From: Martyn White <Martyn.White@arun.gov.uk>
Sent: 22 October 2021 14:06
To: Maria Tomalova <Maria.Tomalova@arun.gov.uk>
Subject: RE: Kents Farmhouse at Climping CM/49/21/DOC

Re Kents House, Climping CM/49/21/DOC

Drawing Title
**WINDOW AND DOOR
DETAILS**

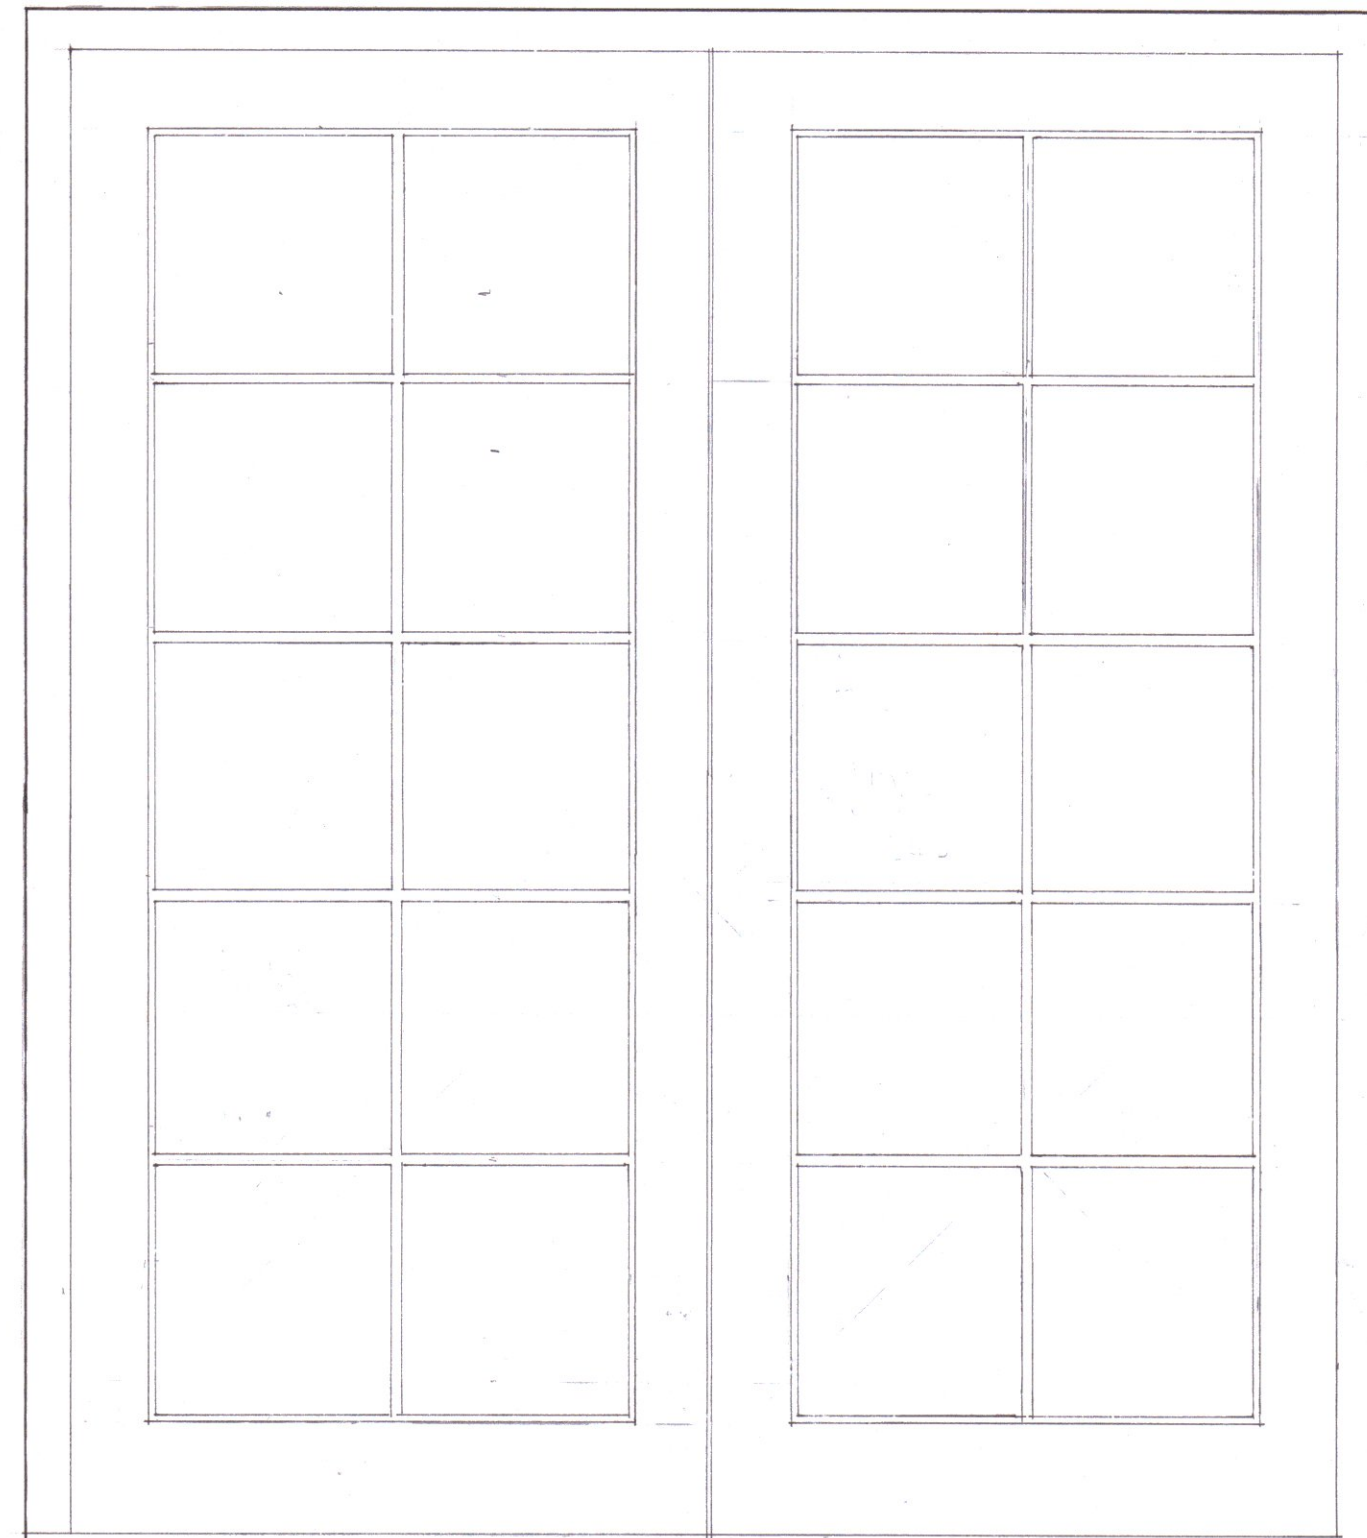
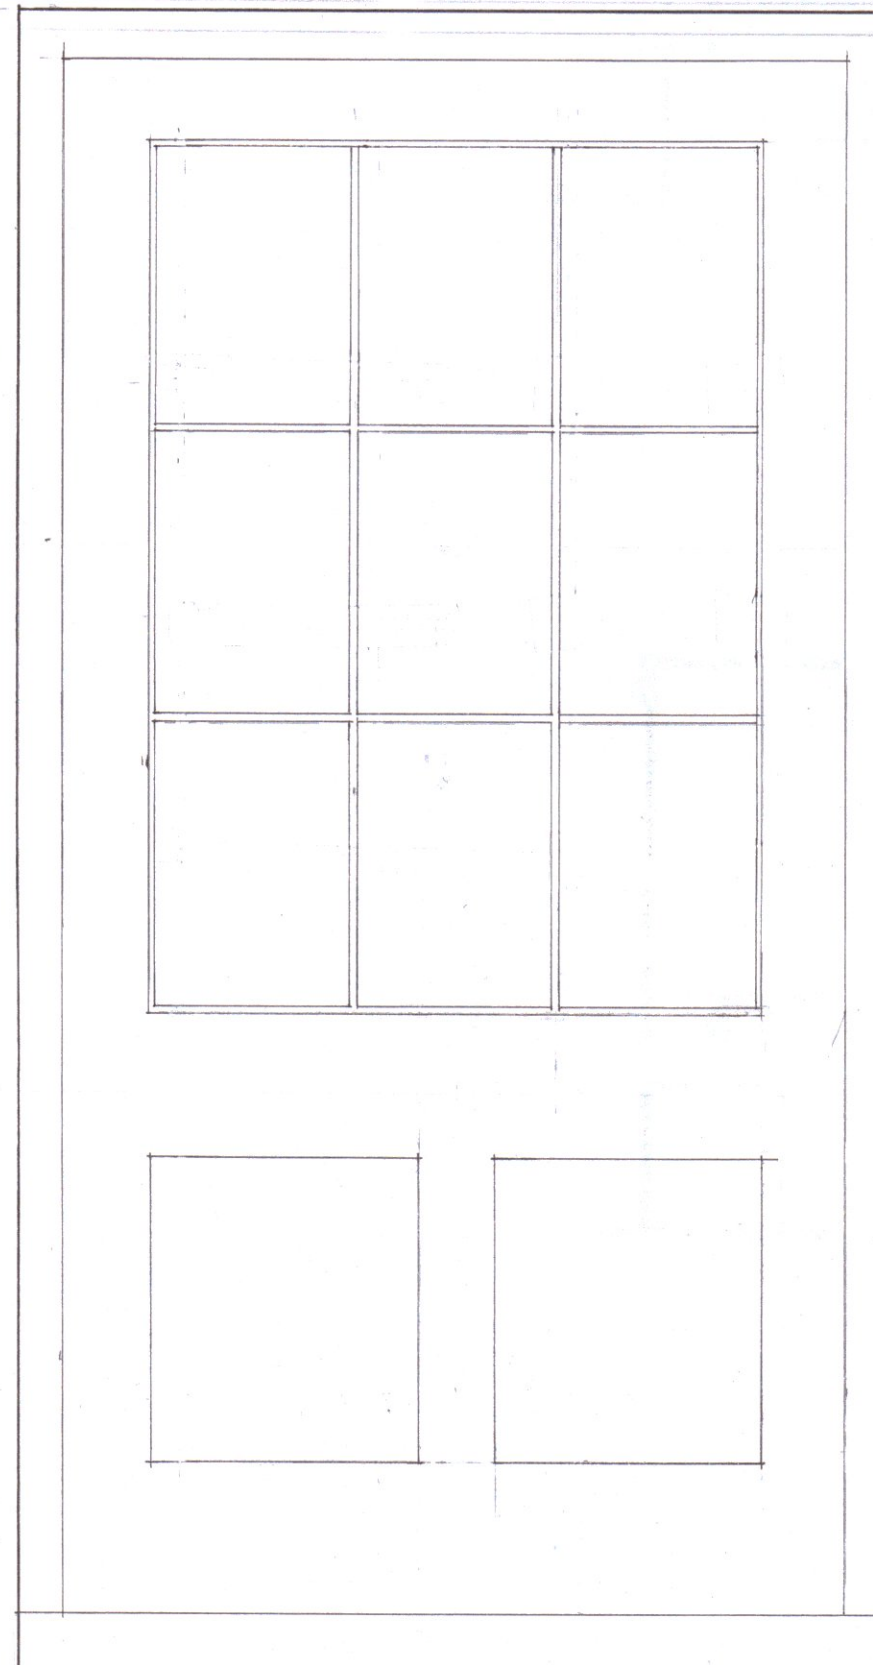
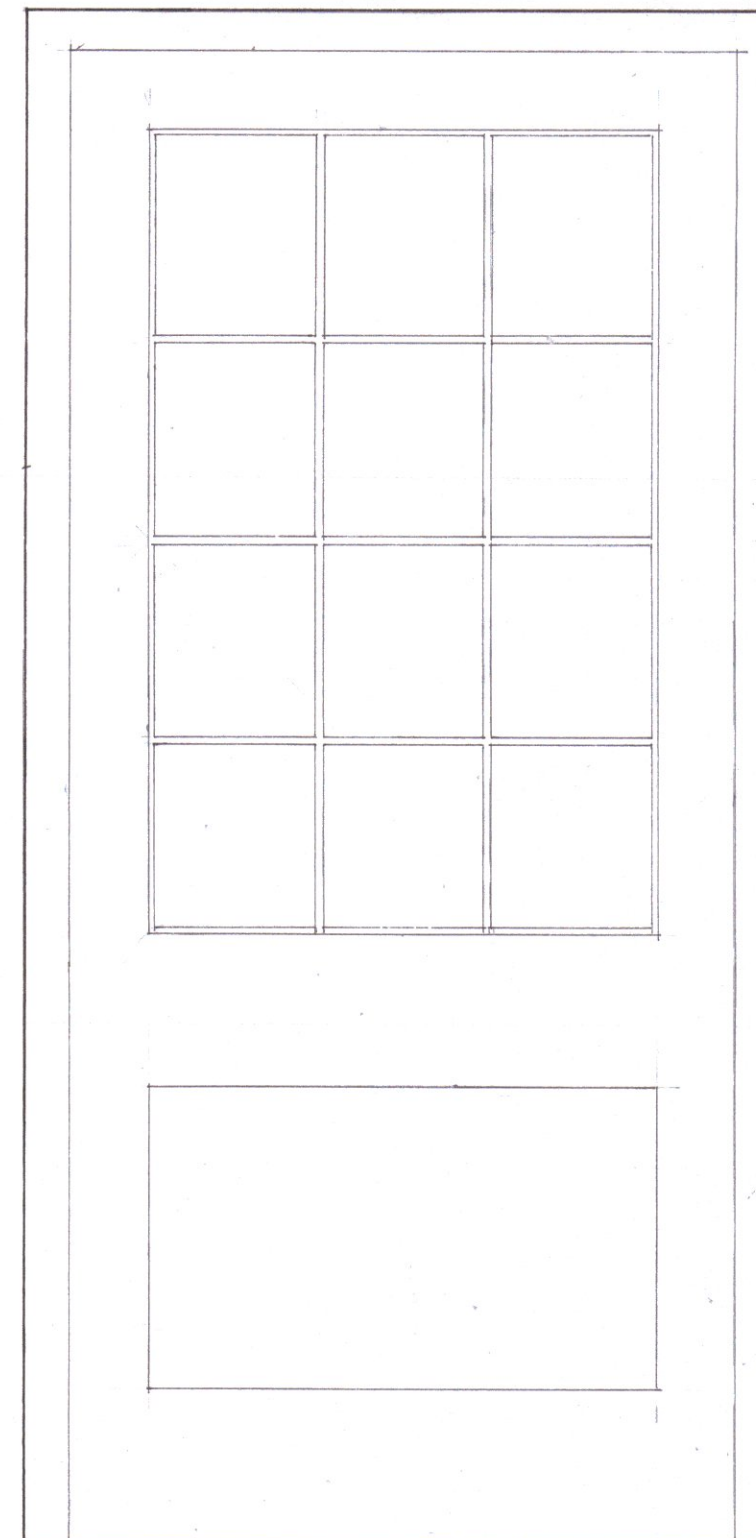
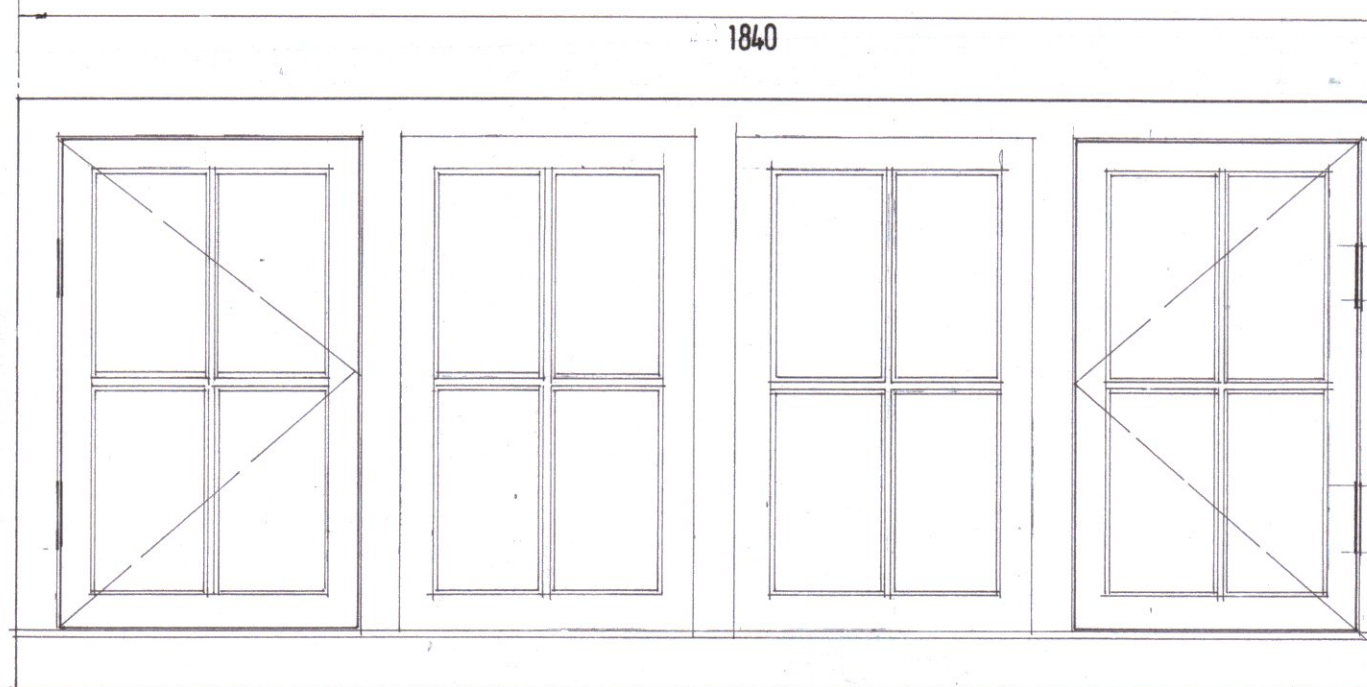
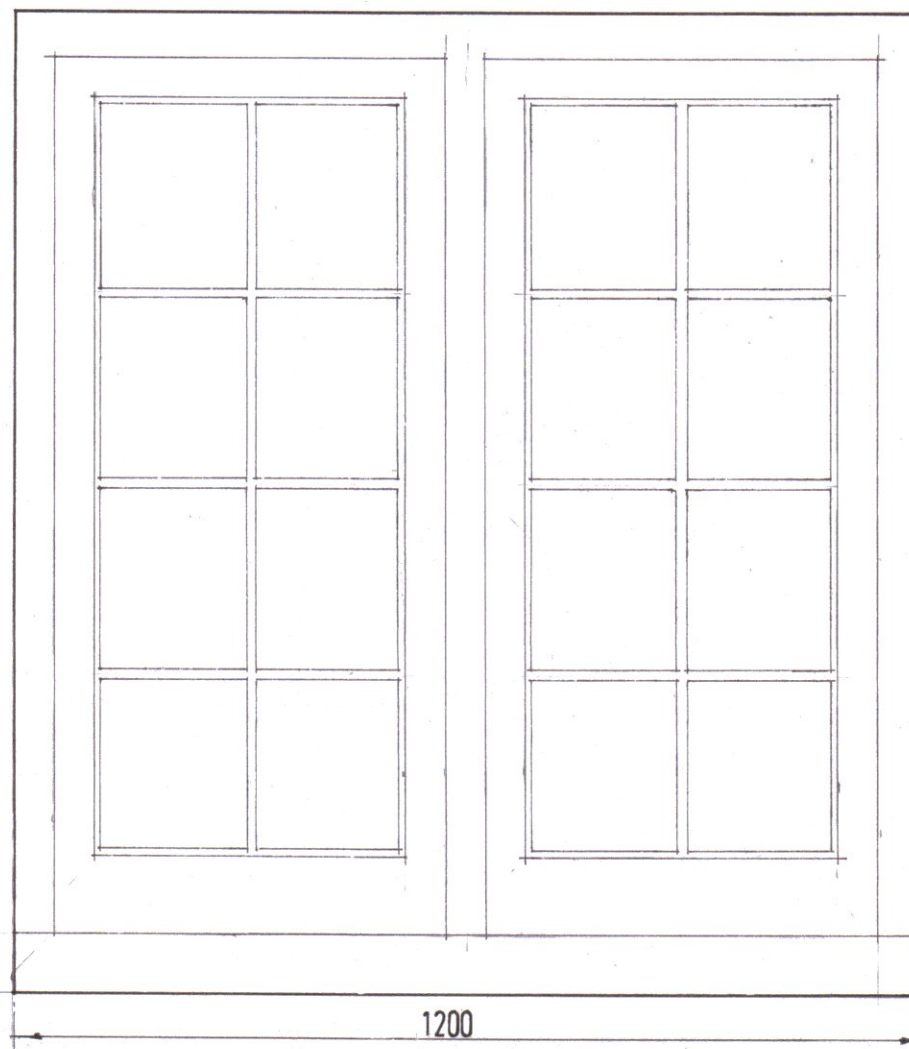
Thank you for your emails relating to detail of windows and safety features associated with the light well. I confirm the following specification:-

Condition no 2 - The drawing for the window sections has come from the joinery company, but they have been instructed following the Discharge of this Condition that all window glazing must be the 4 x 4 x 4 design and not 24mm

The window bars are to be a match to the glazing bars elsewhere in the house they are to frame up each pane of glass i.e. not applied or stuck on imitation glazing bars

In summary the windows, doors and their various sections are to match the period of the house
